# TEXT\_ISH16\_EA1N&2\_Session4\_26052021

Hello, and welcome back, everyone. Just before we begin, Can I check with the case team that you can hear me and that the recordings, live streams and live captions have started. I can see and hear you. And superlines it. Thank you very much. Nice. Thanks, Liam. Okay, and we were up to item C of this part of the agenda, which deals with the outline operational drainage management plan.

Appendix 5: Indicative Attenuation SuDS Basin Figures

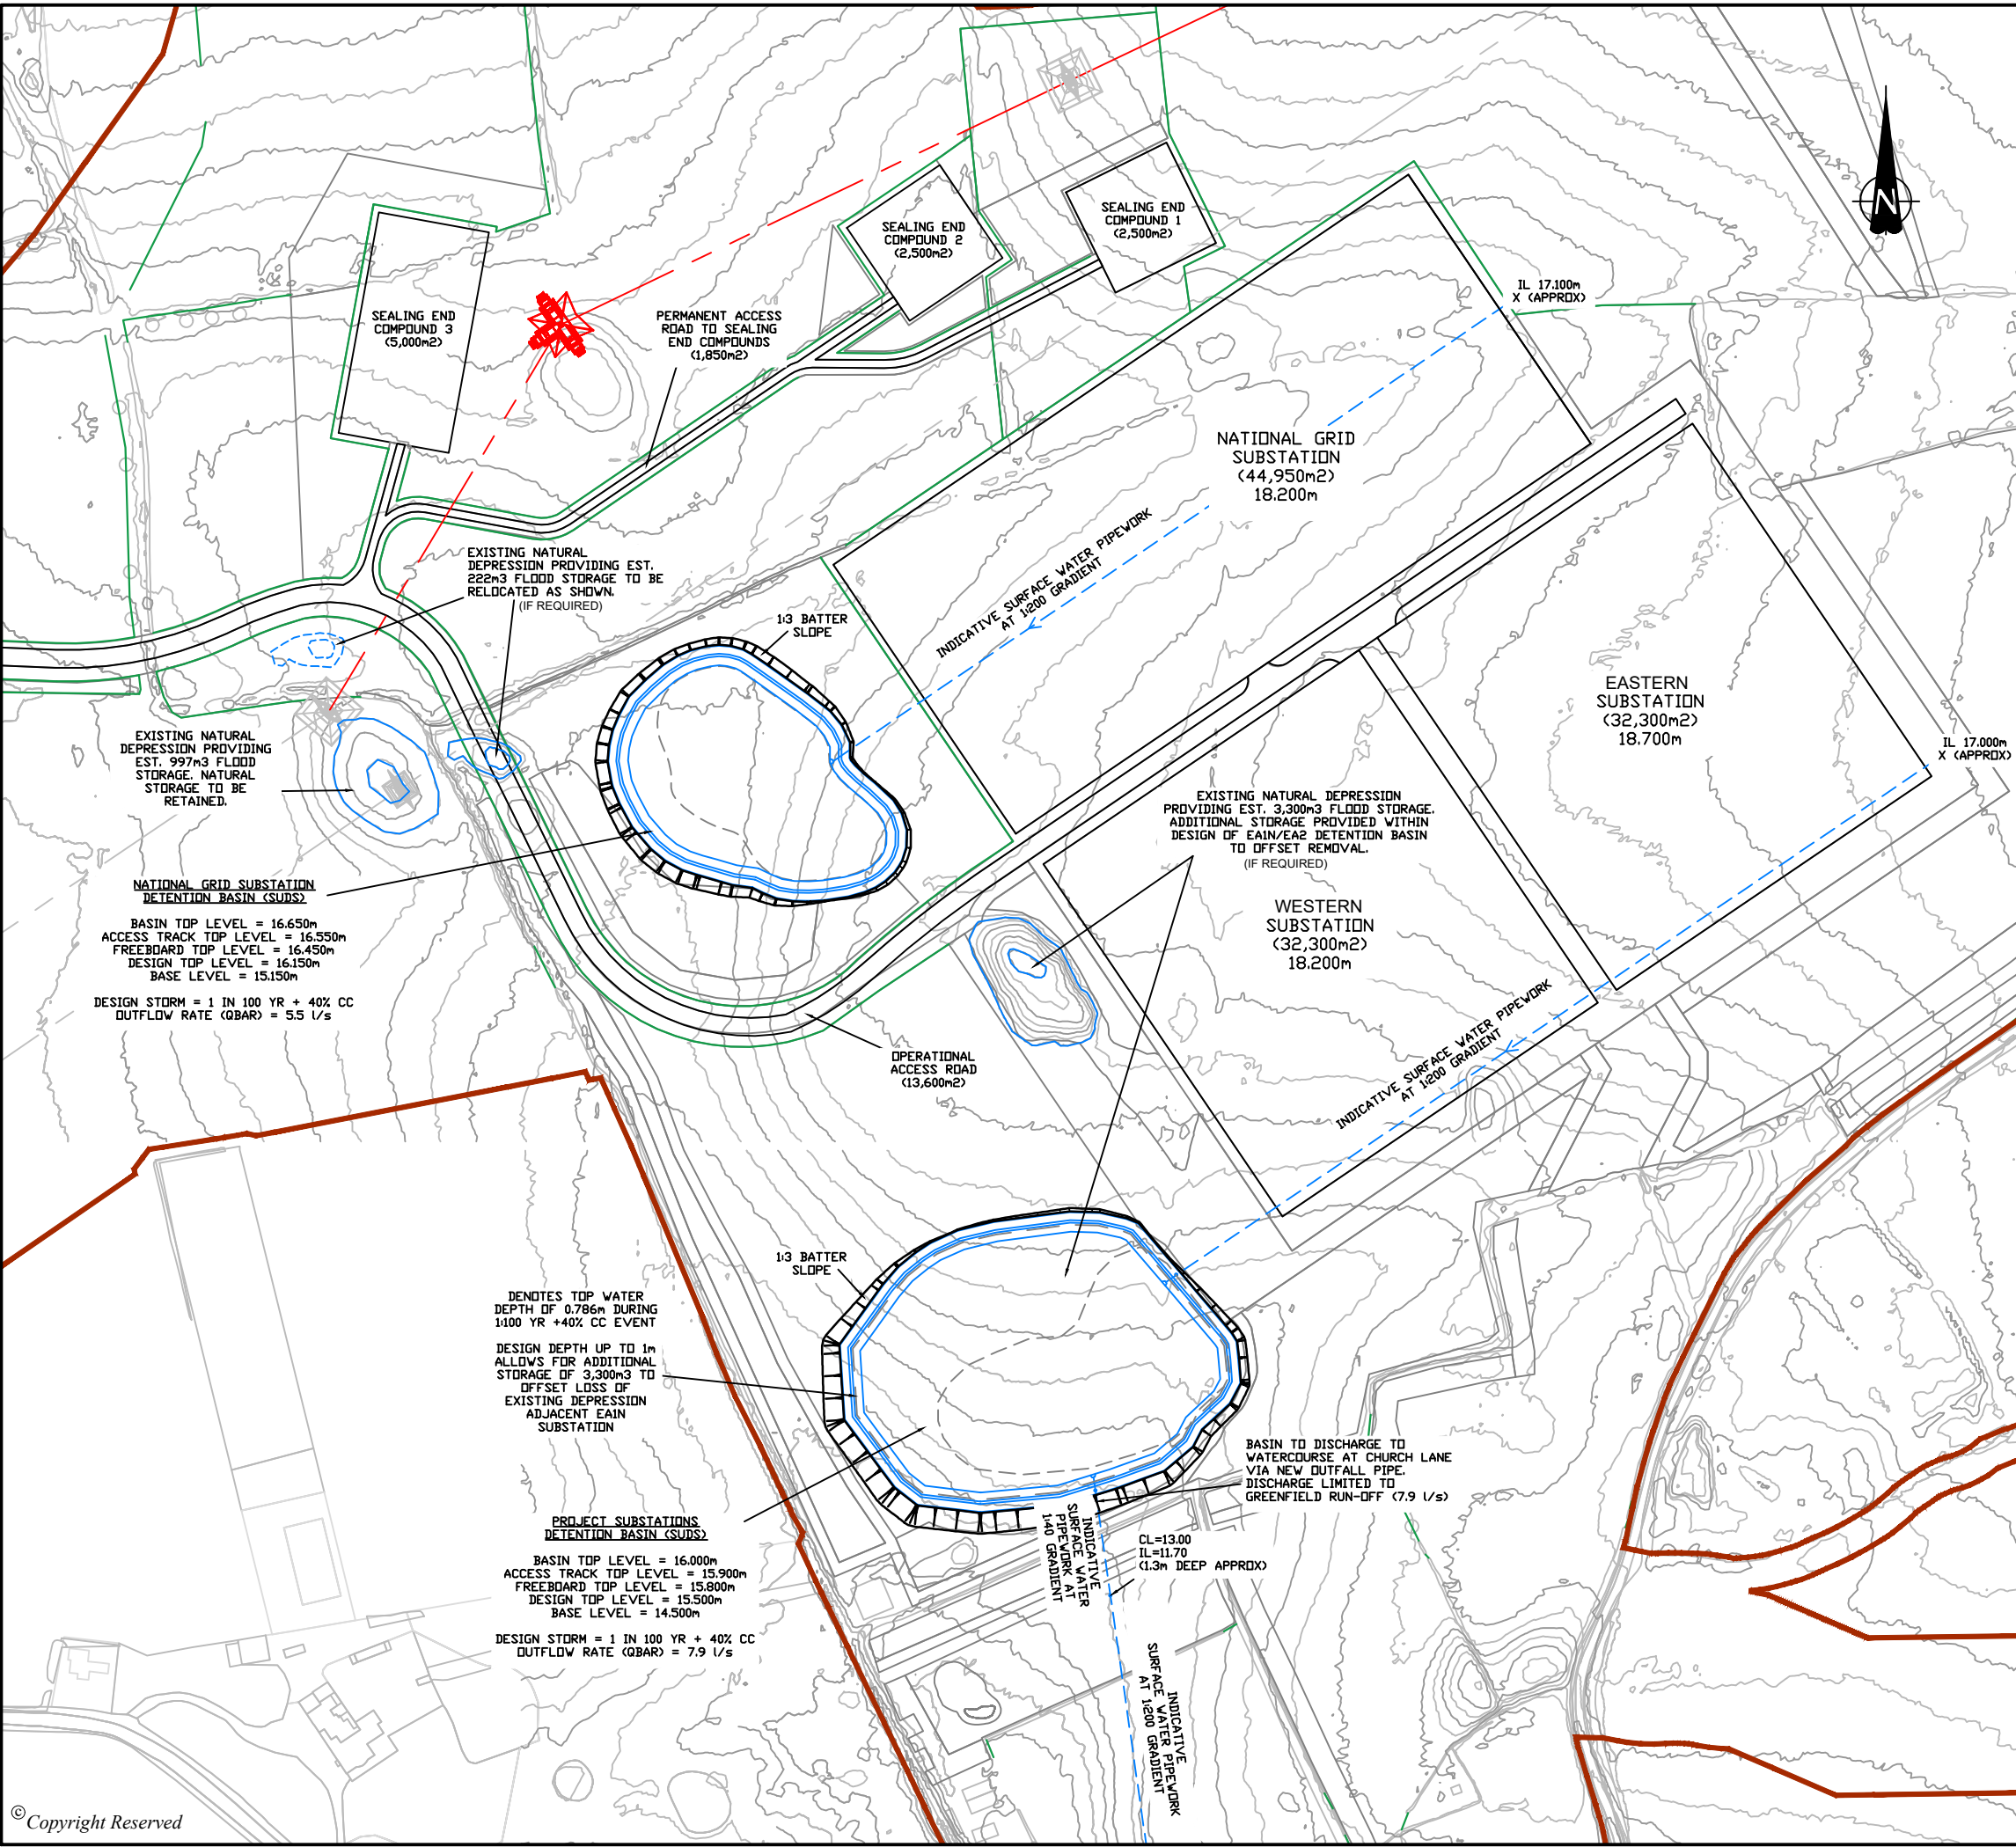
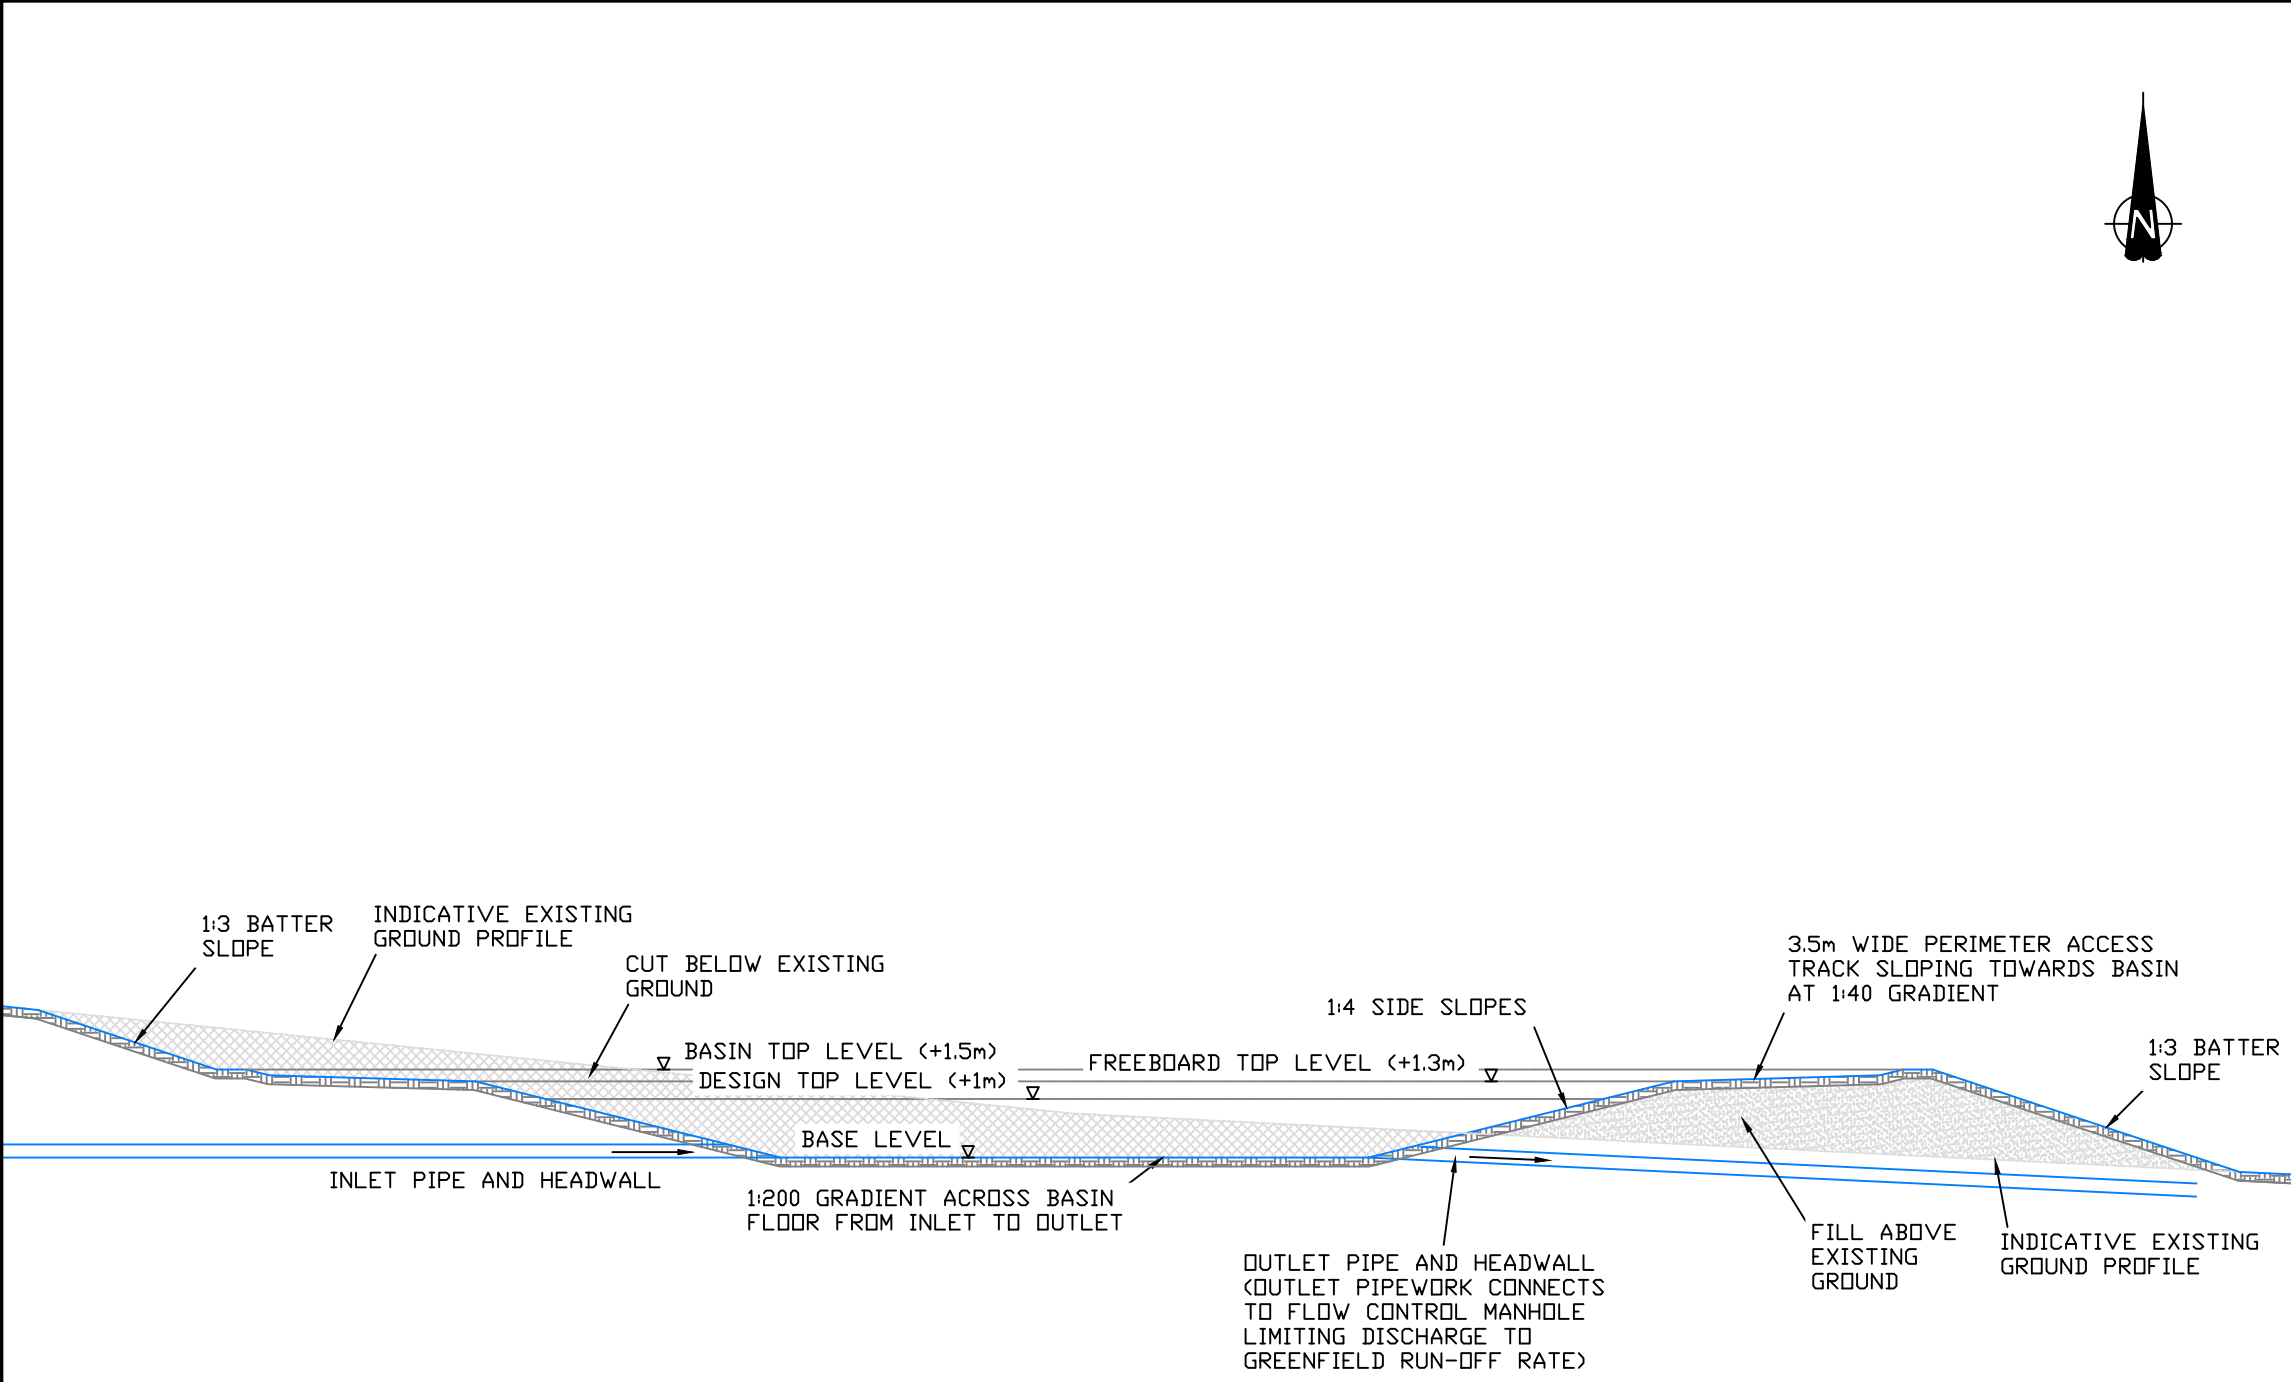
Yep, I'll just point you towards appendix six. And specifically page two of appendix six. This is of the deadline eight outline operational drainage management plan. freeboard top level is listed on this section as plus 1.8 metres. That's contrary to what the applicant has just stated and is outside the scope of this series. That's manual, recommended maximum depth of basins. In addition to that, I would also query having had a flick through the calculations again, and I will note that it's the applicants comments at deadline 10 did challenge me on some aspects of that, and I appreciate that I'd taken the

sections the level shown on the section as the water levels they are actually the base levels is a slight, slight confusion there because you've got a base and top level at plus 2.0 metres but your freeboard finishes at plus 1.8. In the calculations, I believe that I can't remember if it's the project or the National Grid substations, one of them is slightly over one metre water depth, not massively, but slightly, we would we would still accept it, I think it was only 20 millimetres or something like that. My concern would be that when you then add the one in 10 rainfall event after 24 hours on top of what would the water level be then it could potentially be greater than a metre. But I think the bottom of bottom line is we don't know.

Just contrast, we're at risk of going over old ground here. And to try and keep things on track. In terms of the deadline eight submission, I just asked that the applicant in future submissions of the outline, operational journeys management plan, if you could please mark, the maximum water level on the sections, that would probably help the examining authorities who will most likely not go through all of the calculations. So that would be the depending on the drawing downtimes. multi level after the one in 100, or after the 24 hour period, with the additional one in 10. If you could just put down the sections are being appreciated. Thank you.

Recent on behalf of the applicants. I believe that the matters of the that can be easily reviewed, however, are not the point of Matt Williams that some of the ponds will be over a slightly over the one metre deep. And this is something we can rectify by increasing slightly the footprint of the pond to lower the height of the water.

Is that is that possible? Yes. Thank you. Mr. Carpenter, did you have to have your hand raised? Or was it the same point?
